**KIRKLEES METROPOLITAN COUNCIL
INVESTMENT & REGENERATION SERVICE**

DELEGATED DECISION TO DETERMINE PLANNING APPLICATIONS

Reference No:	2023/62/93771/W
Site Address:	124, High Street, Scapegoat Hill, Huddersfield, HD7 4NJ
Description:	Erection of single storey side extension (Listed Building)
Recommending Officer:	Molly Storer

Drawing No: **(100)01** Rev No:

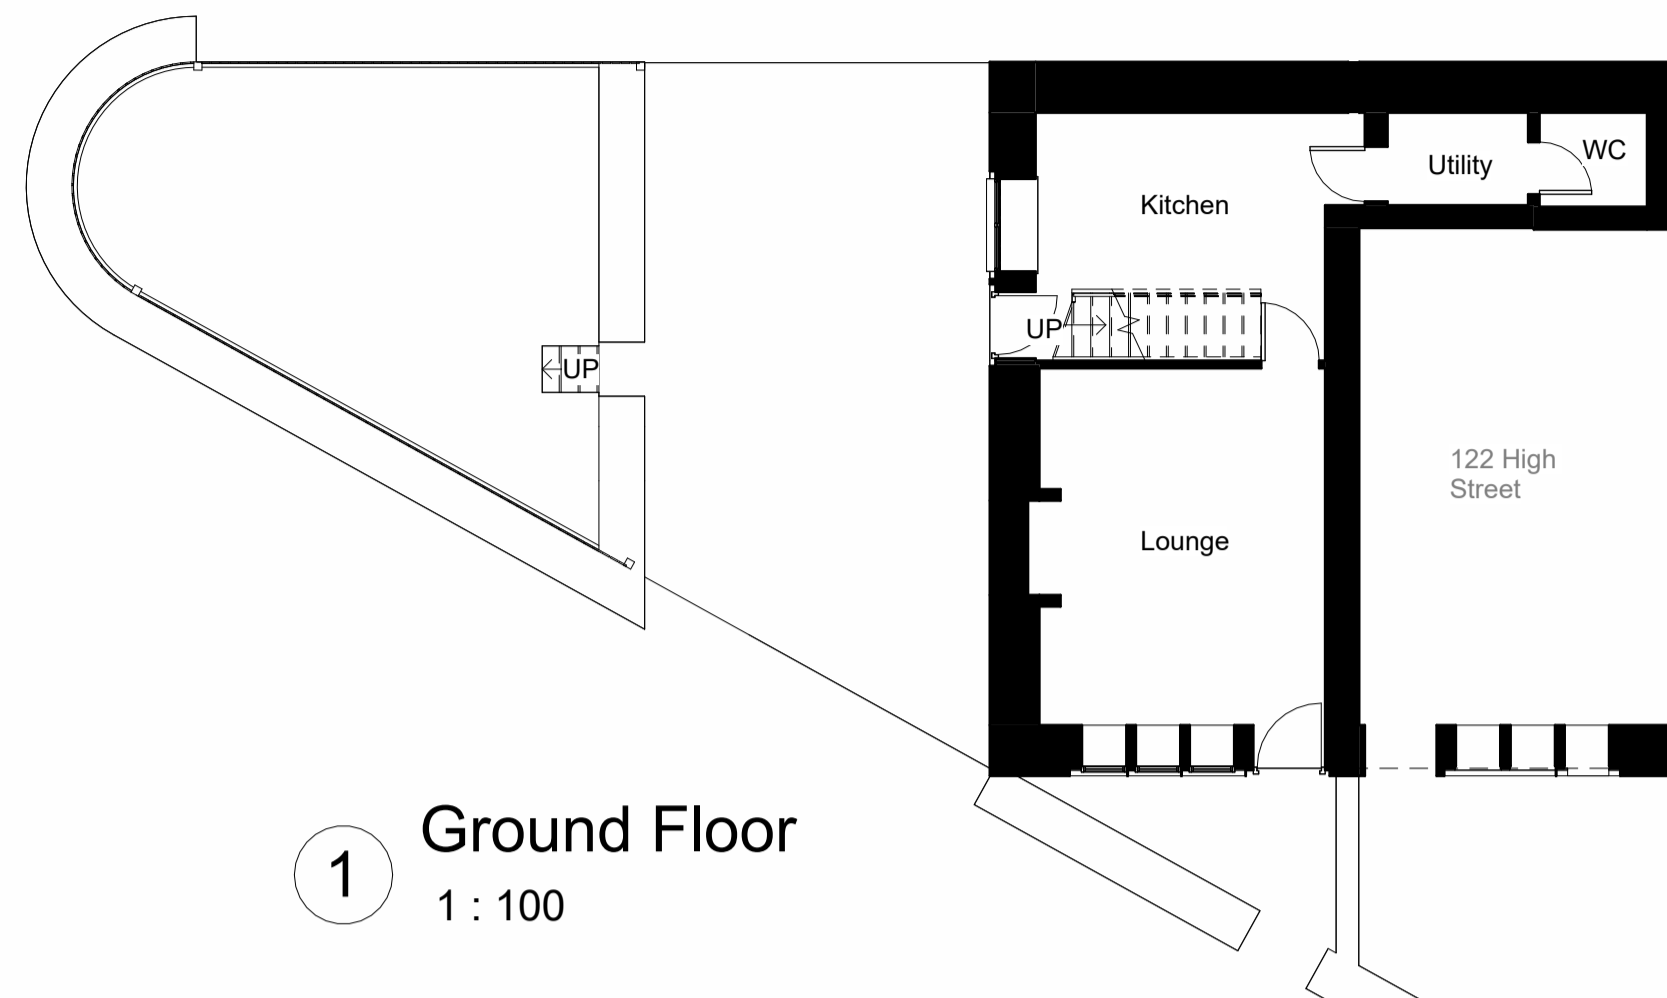
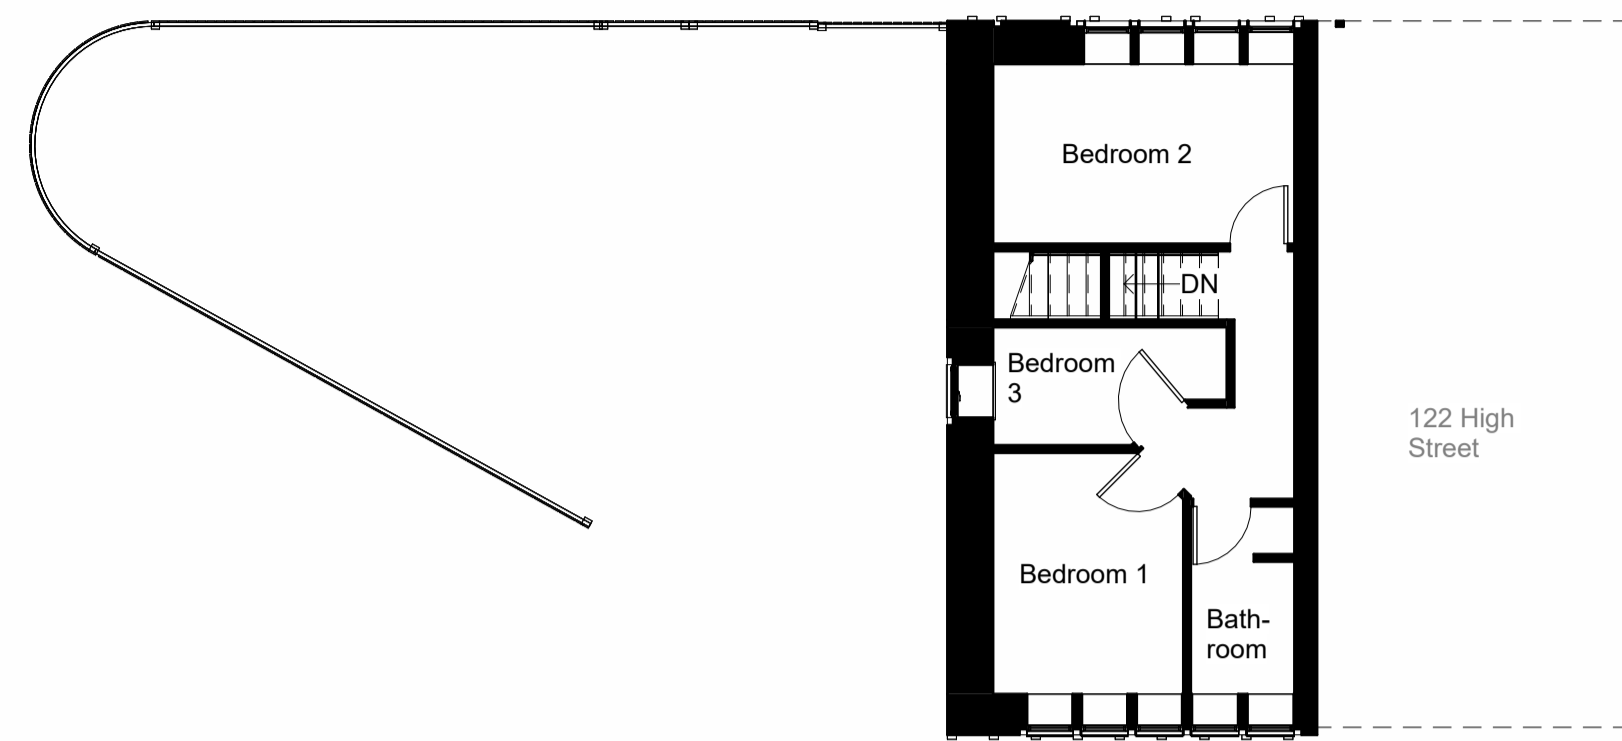
- The proposed opening between the kitchen and extension be slightly reduced to retain small nibs, to allow for legibility of the historic wall line and former window and door openings.

- That the window and proposed door need to be reversed so that the mullions windows are on the front elevation and the proposed door is on the side of the extension. The rationale behind this was that the mullions to the front it will continue the rhythm of the building, matching the window details which are to the front elevation of the main building. Equally, moving the doors to the side elevation would in some way relate to the existing arrangement, with the side door.
- That the door should be reduced to a single door, however, it would be possible to include a pair of mullions to the side elevation which would further reestablish the exiting openings.
